ARUN DISTRICT COUNCIL

We are writing to make known our objection to the following planning application - BR/91/11/99 Hillsborough Road, Bognor.

Dissapproval of REF BR/91/11

Proposed roof extension and loft conversion
79 Hillsboro Road Bognor Regis

DRAWING TITLE:
Proposed Layout Plans & Elevations

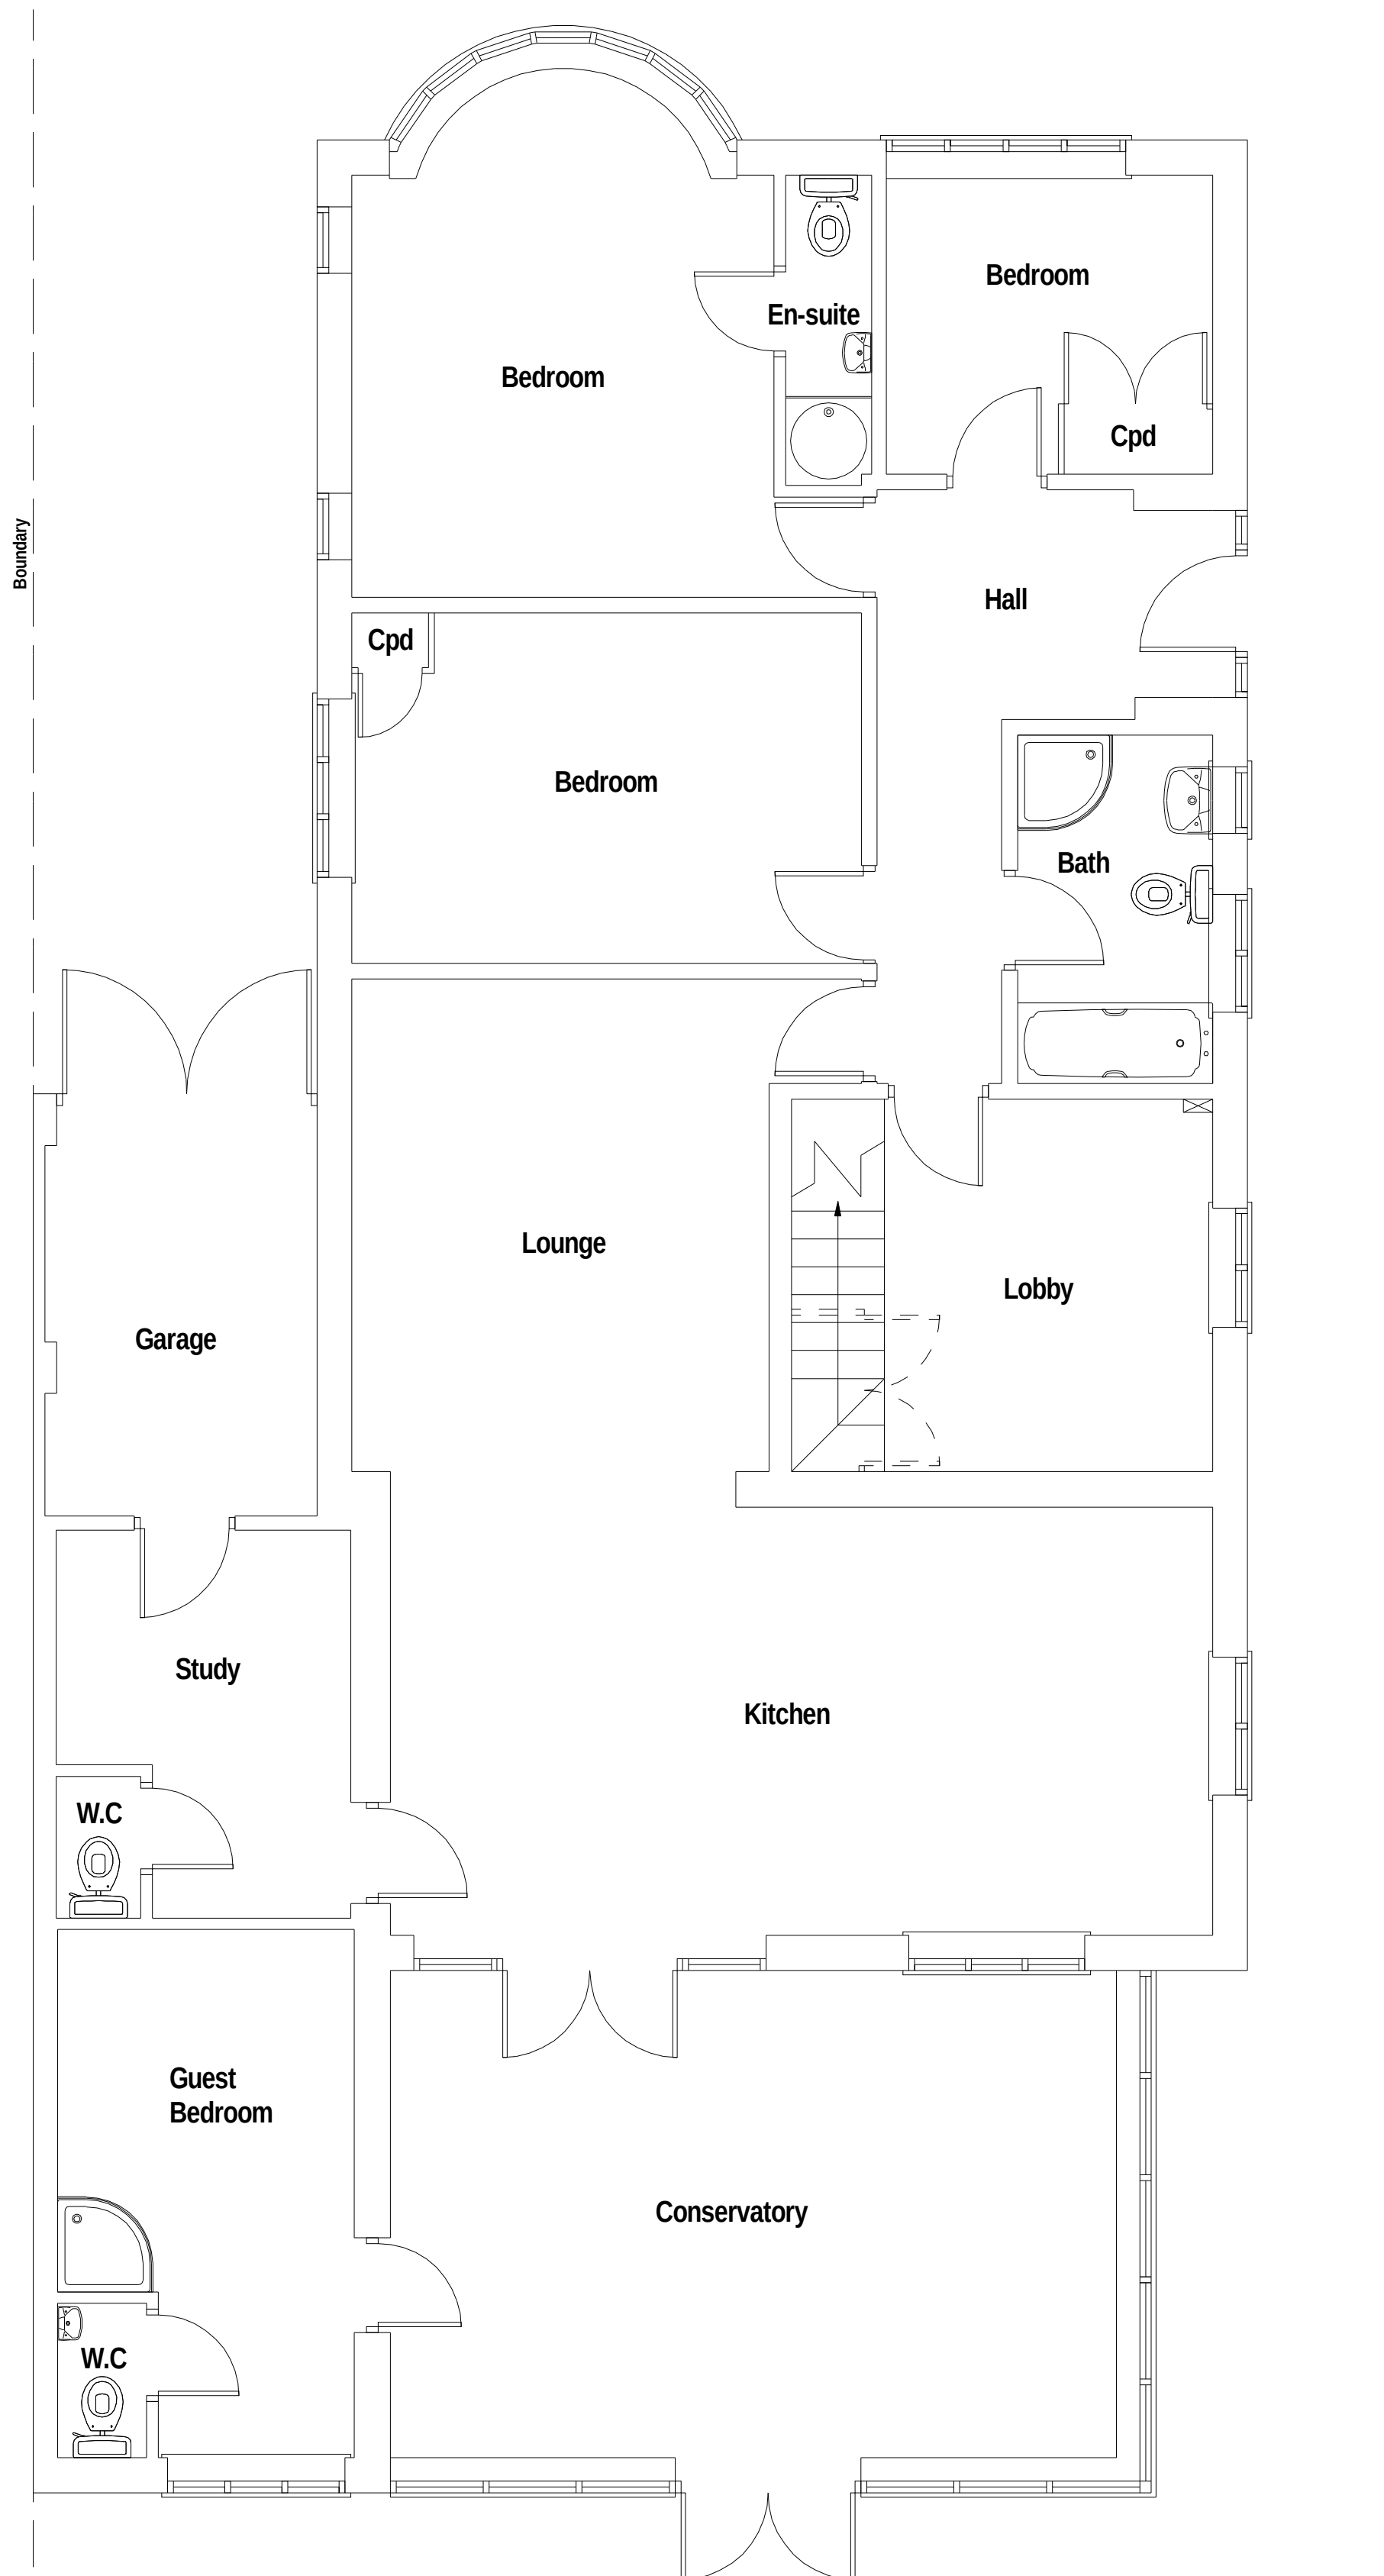
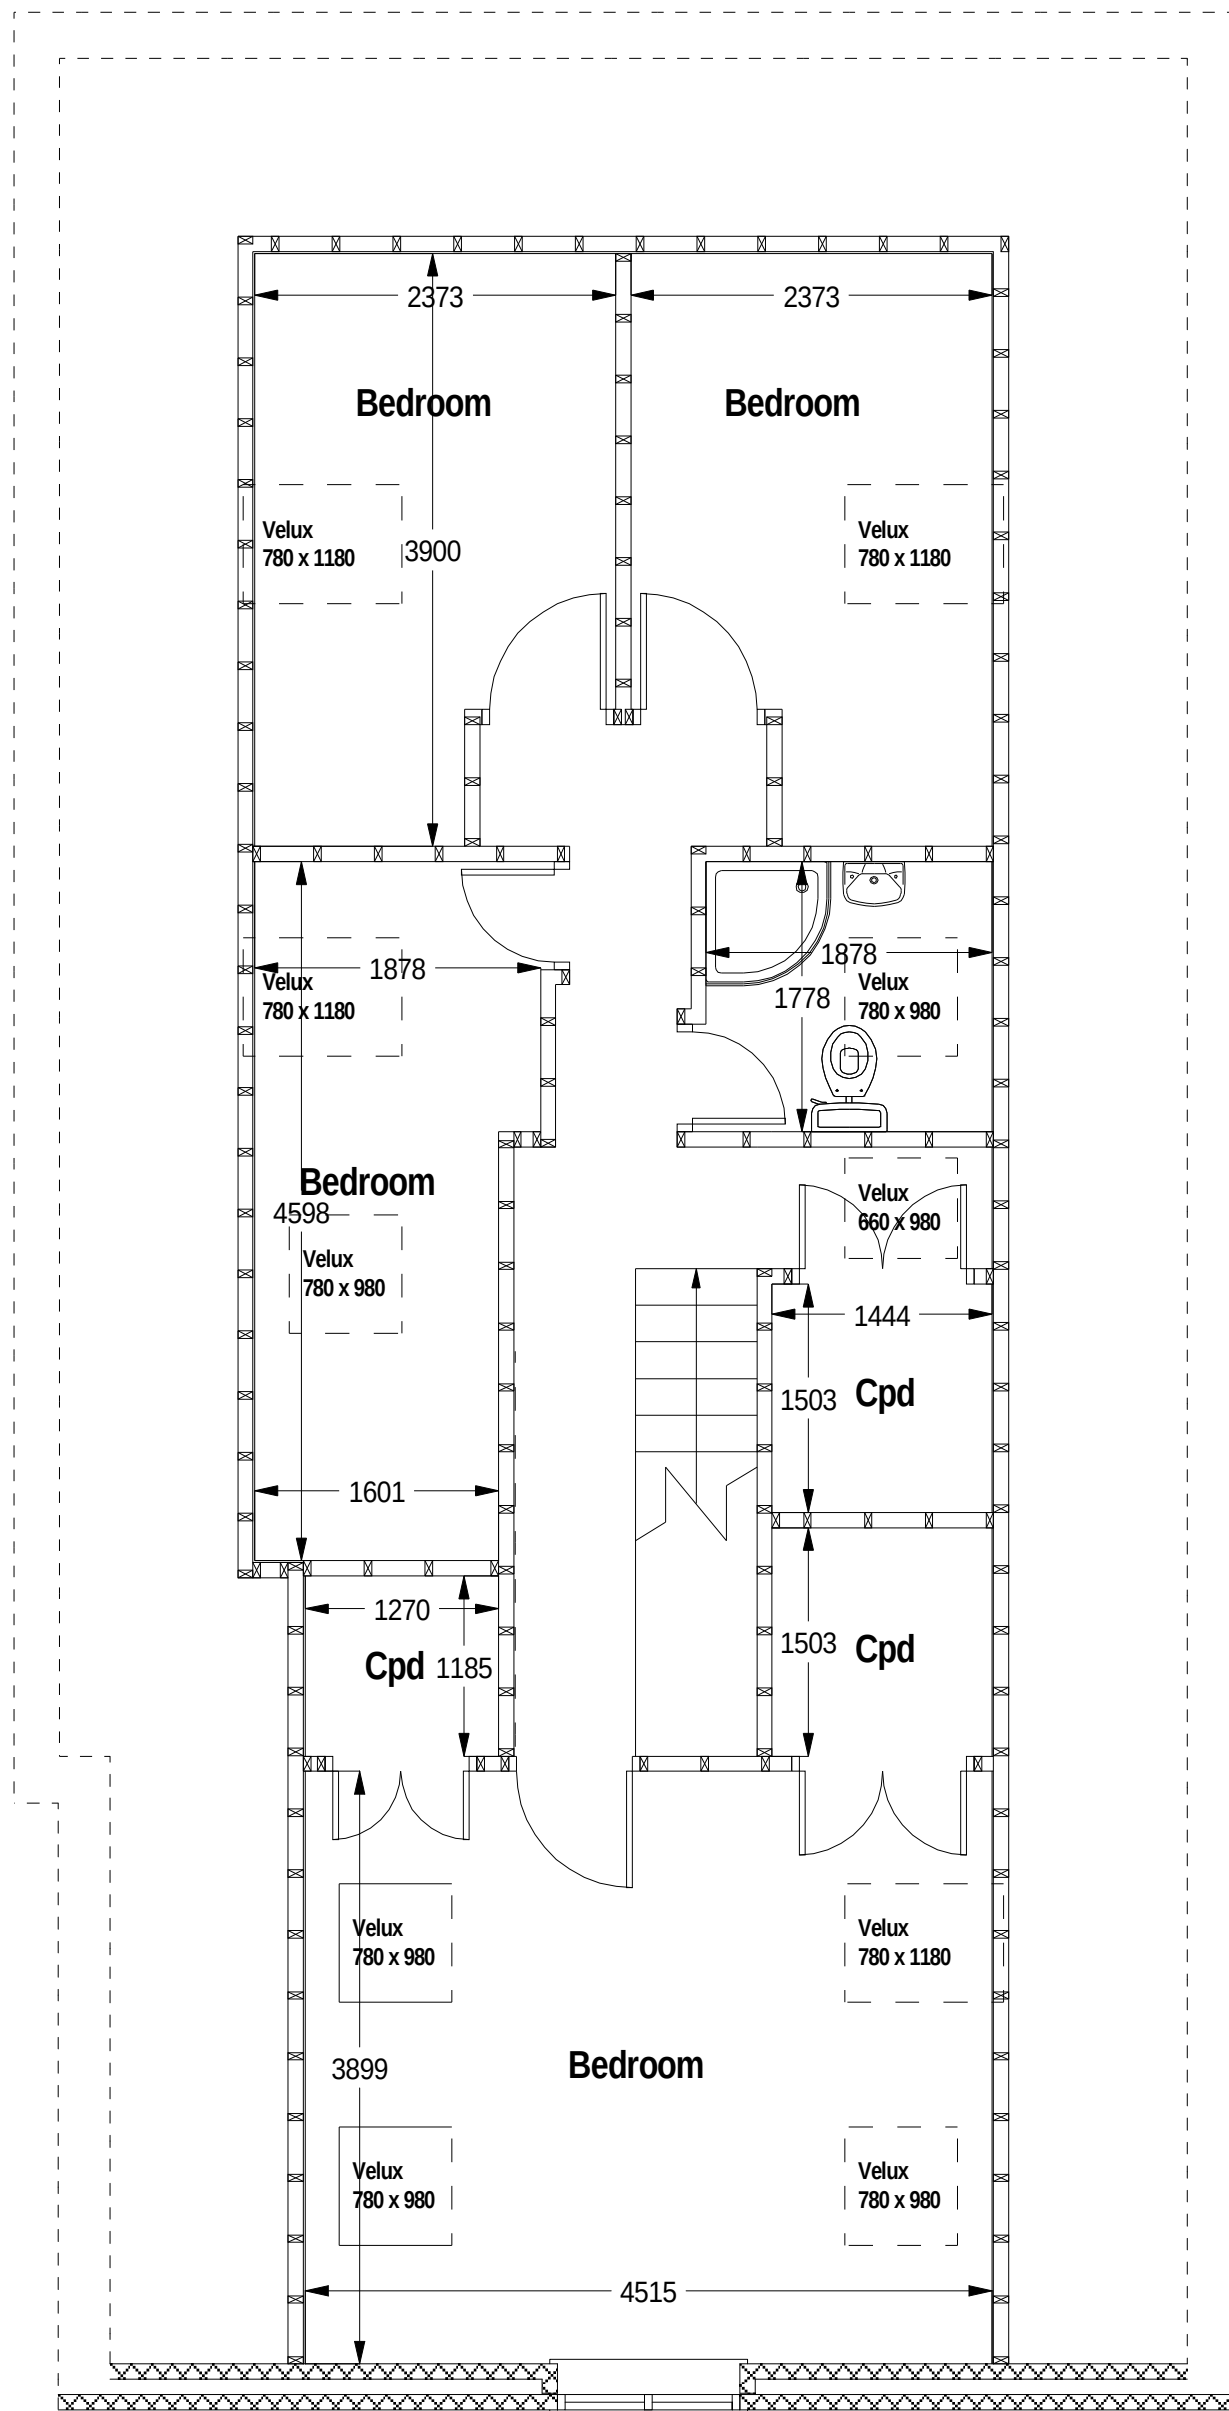
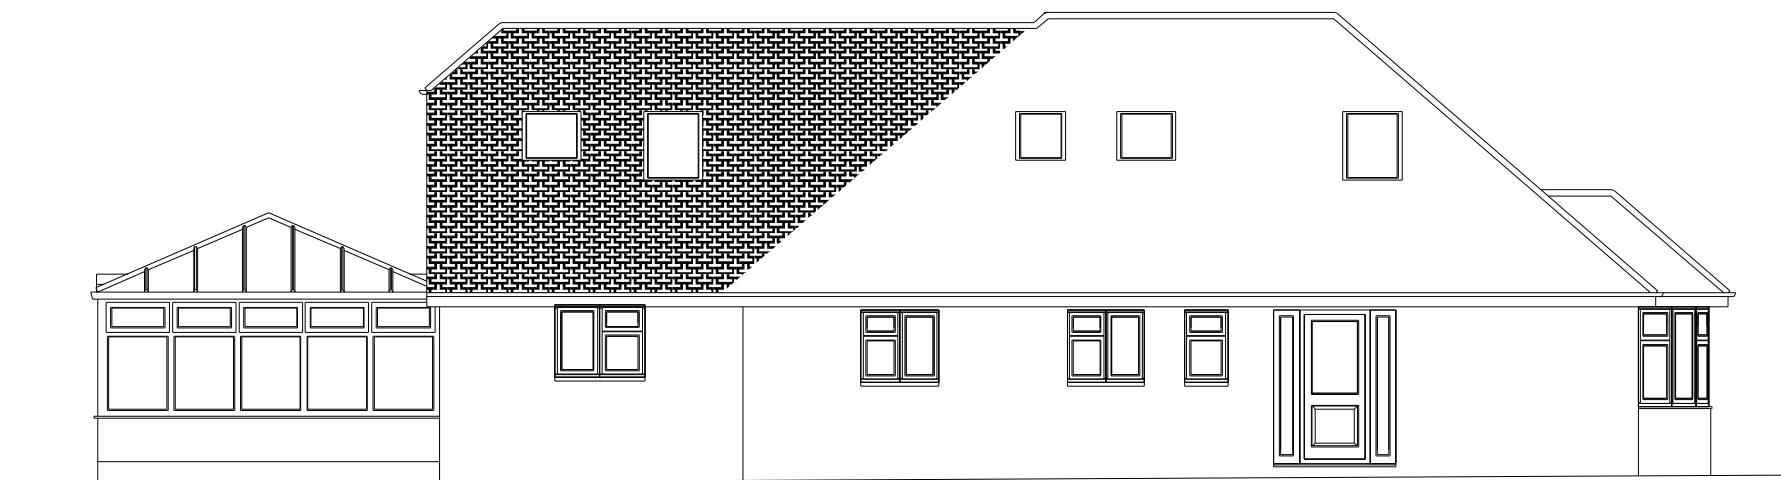
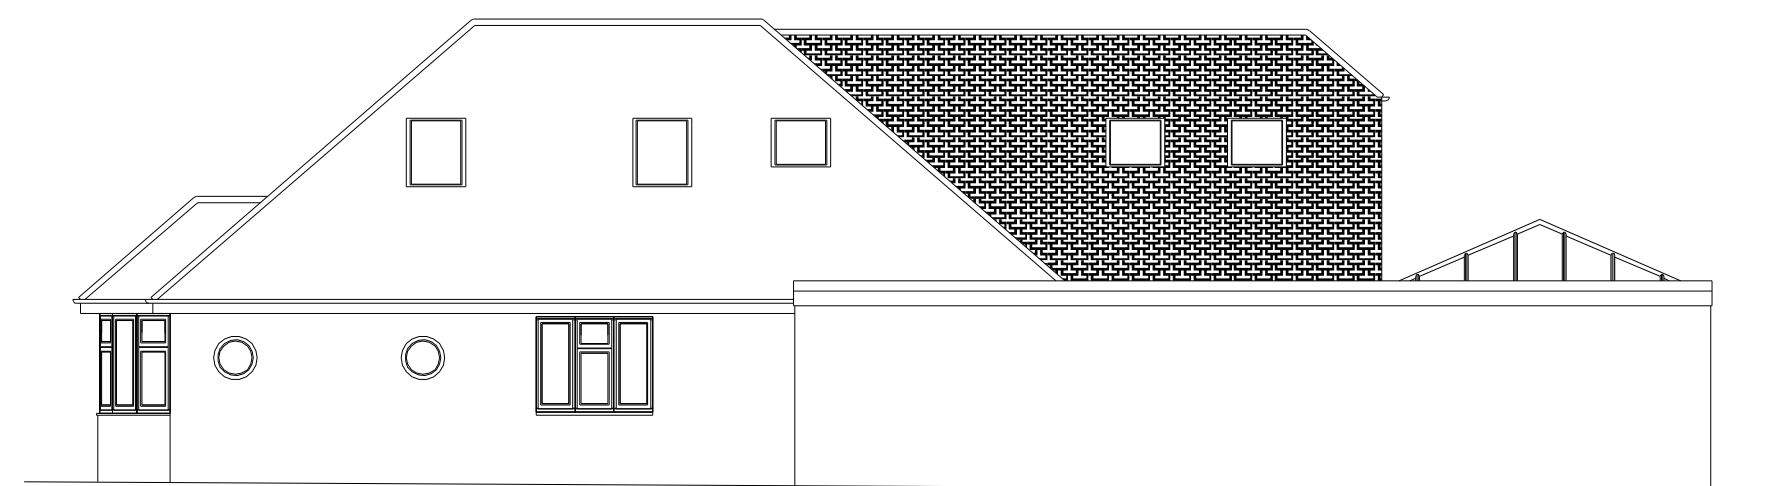
This extension is far too big for the situation it's in - in between three or four bungalows. We have a small back garden which will be totally overlooked, with the loss of privacy, sunlight etc. This extension ruins virtually the whole length of our rear garden.

I understand looking on the internet my neighbour who's property runs along the bottom of 3 Bungalows on the Chichester Rd. is planning a High railed roof extension with lots of windows overlooking all our properties 2 of which are totally secluded from anyone looking into our gardens. due to this my neighbour has a large deciduous in his garden and was the reason for buying this Bungalow.

*I DO NOT WANT THIS TO GO A HEAD IT WILL STOP MY LIGHT. AND FEEL OVER
POWERING. □
MR WAYNE HAS SENT THIS EMAIL FOR ME. MR LEE*

*IF THIS GOES AHEAD IT WILL BLOCK OUR LIGHT AND SUN .
AND TAKE ALL OUR PRIVACY AWAY.
SURELY THIS PROPERTY IS OVER DEVELOPED ALLREADY.
HOWEVER I DONT MIND DEVELOPMENT TO EXCITING LOFT WITH ONE VELUX
FROSTED MY SIDE .*

*NOT HAPPY WITH NEW BUILD AT REAR. FEEL THIS IS OVER POWERING TO
PROPERTY'S AROUND . WHICH ARE BUNGERLOWS NOT HOUSES.*
